WEST SUSSEX COUNTY COUNCIL CONSULTATION

TO:	Arun District Council FAO: Amber Willard
FROM:	WSCC - Highways Authority
DATE:	11 February 2020
LOCATION:	Beachcroft Hotel, Clyde Road, Felpham, PO22 7AH
SUBJECT:	FP/13/20/PL Change of use of highway land to outdoor seating area together with new fence & planter.
DATE OF SITE VISIT:	N/A
RECOMMENDATION:	Advice
S106 CONTRIBUTION TOTAL:	N/A

PROJECT The Beachcroft Hotel - Terrace
TITLE Proposed Site Plan
SCALE As Noted
DATE 11/01/20
DRG NO IBA/526/02
REVISIONS A

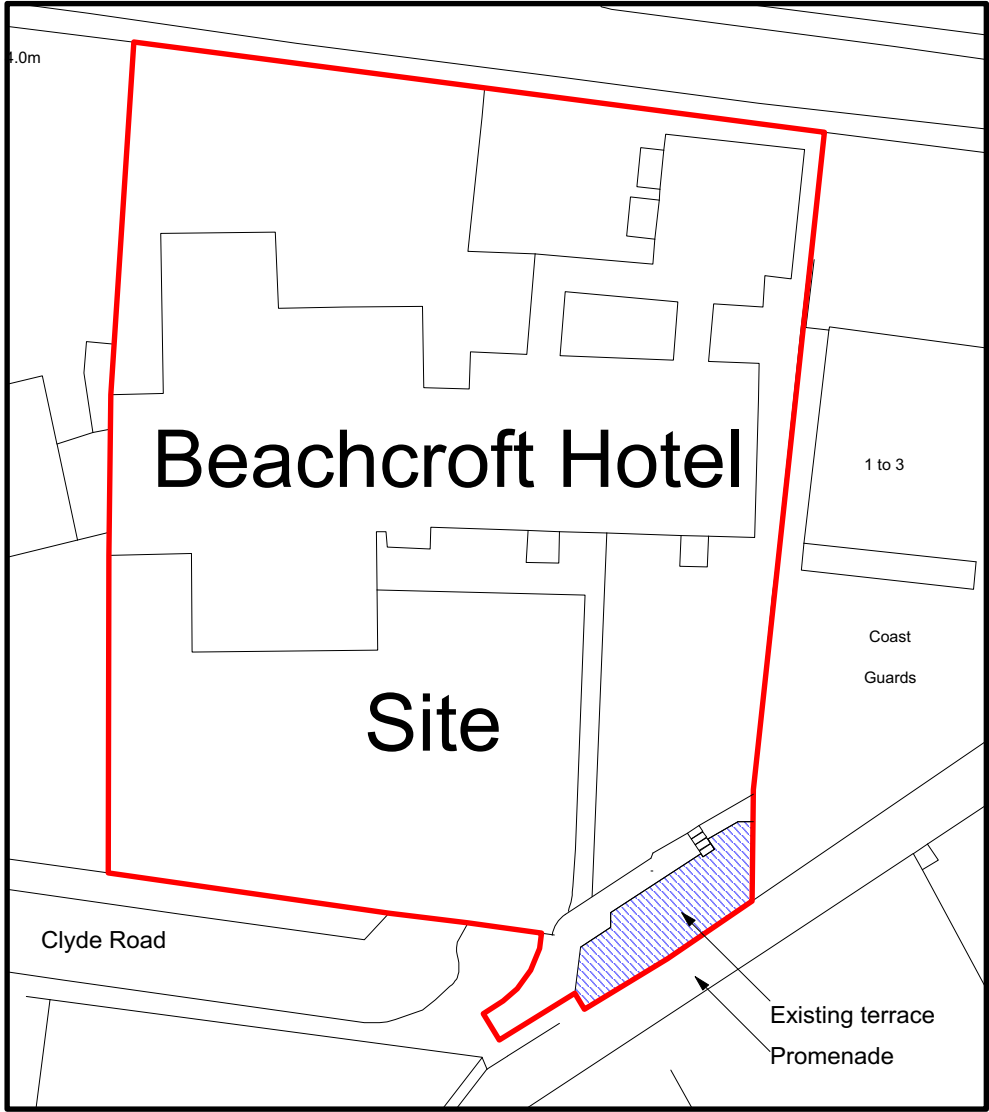
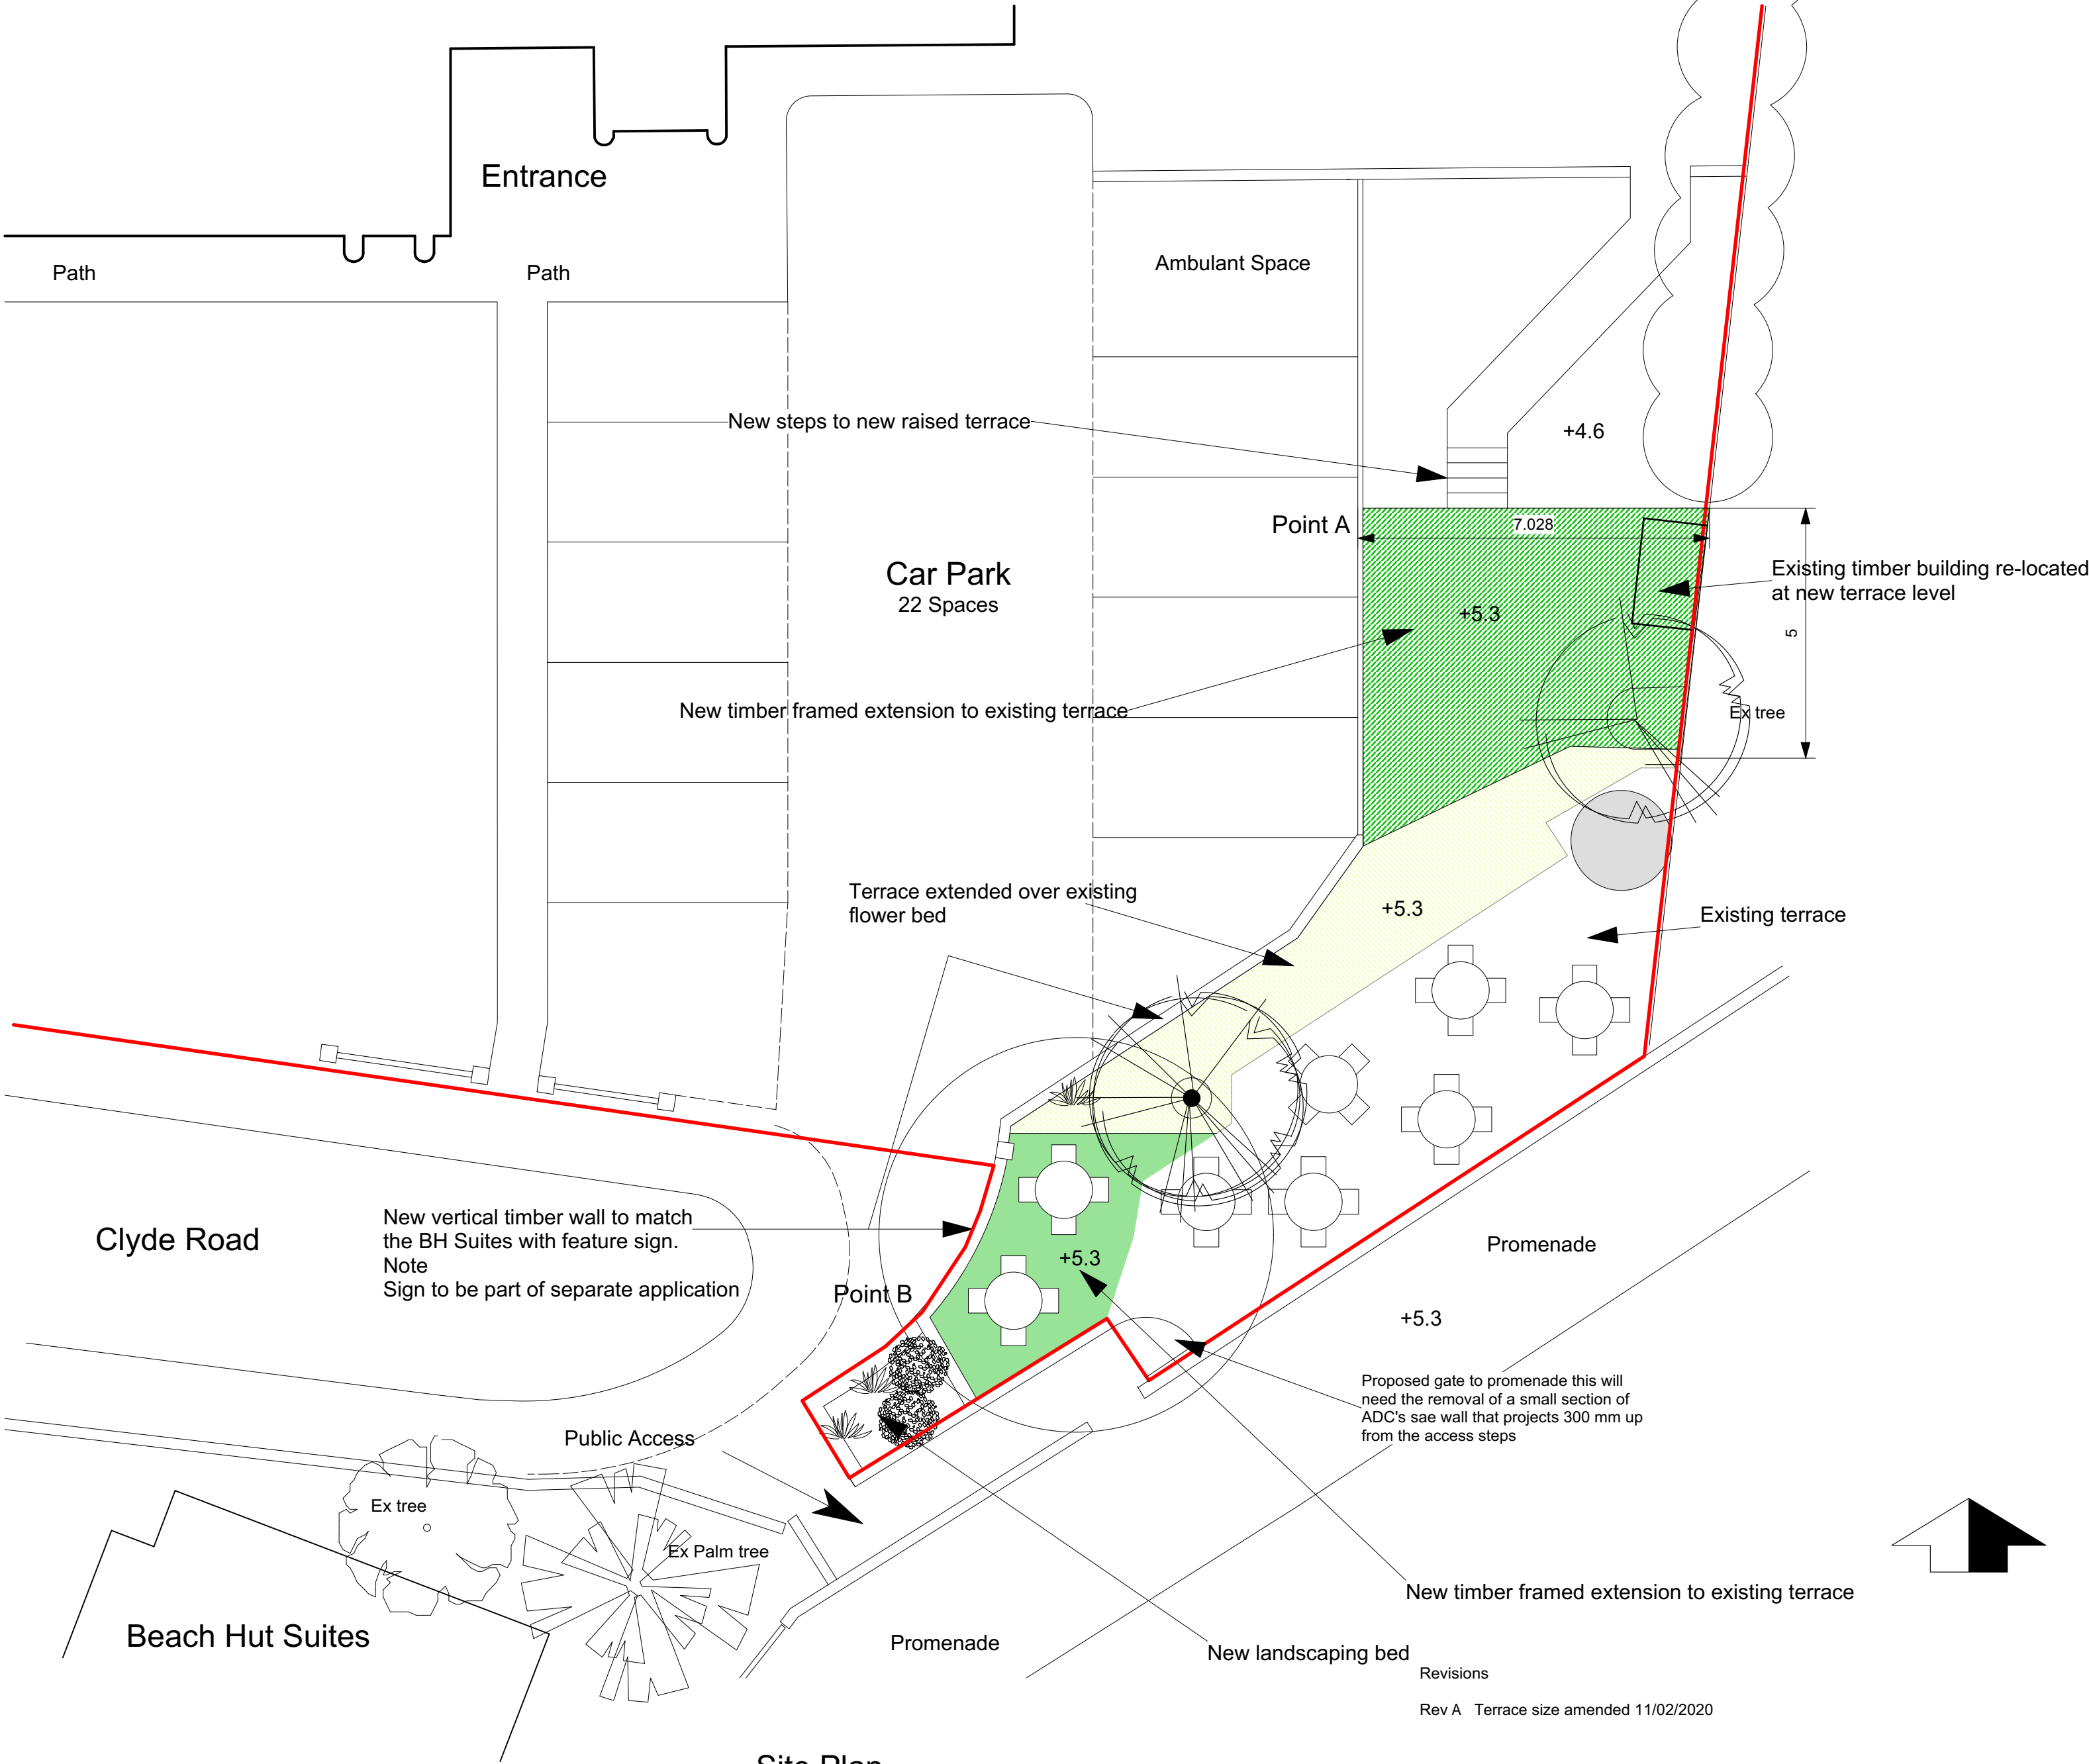
The Design & Access Statement indicates that the land in question is assumed to be owned by West Sussex County Council (WSCC). WSCC in its role as Local Highway Authority (LHA) can confirm that WSCC has no land ownership in this location. However, part of the proposed seating area may encroach into publicly maintained highway.

Alternatively, the LHA advises the applicant to consider modifying the plans to ensure the proposed seating area does not encroach into publicly maintained highway. This way, a licence will not be required.
